Ribble Valley Borough Council
By email

Your ref: 3/2023/0156
Our ref: DC/23/1617
Date: 27-JUN-23

Location: Dog and Partridge Hesketh Lane Chipping PR3 2TH
Proposal: Conversion & extension of former Dog & Partridge to form one dwelling & 6 residential apartment

Title: **PROPOSED DRAINAGE LAYOUT**

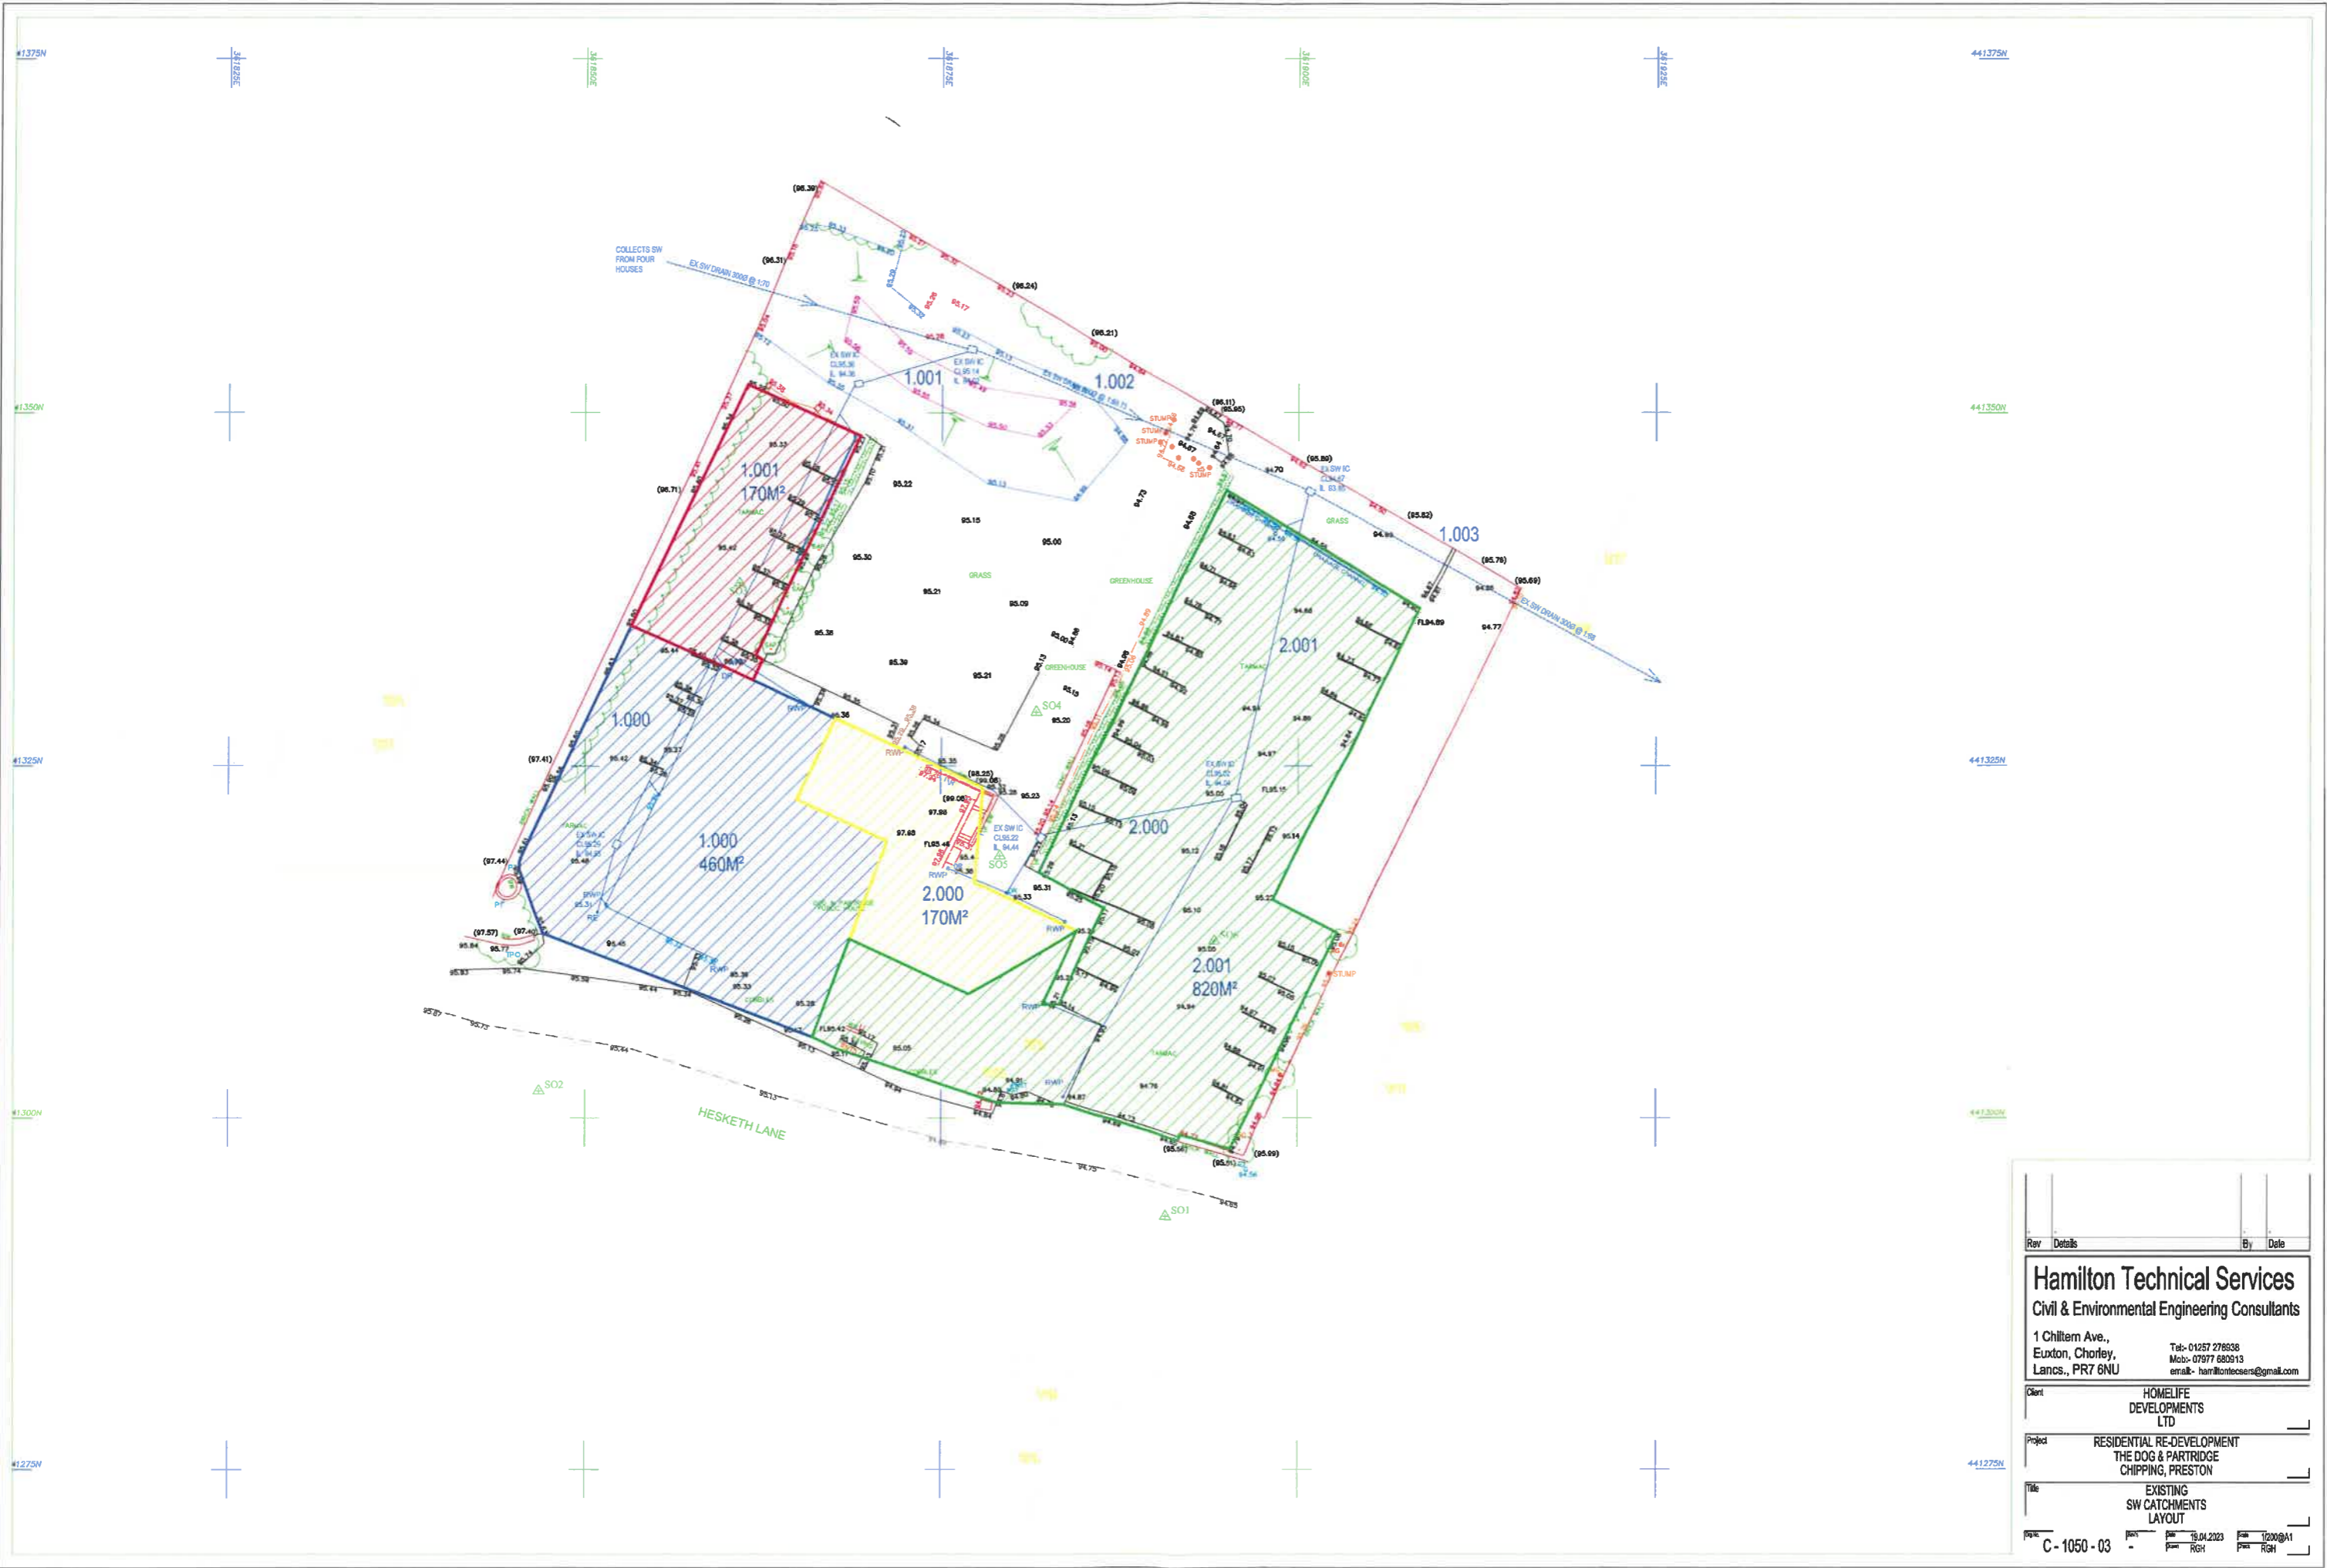
The surface water drains indicated on the drawing are not mapped on our systems and we believe that they could be private drains. Could the applicant confirm the status of indicated drains they are proposing to connect to.

Detailed design shows foul being treated before connected to (potentially) public surface water drain.

United Utilities will not accept treated foul into public surface water network.
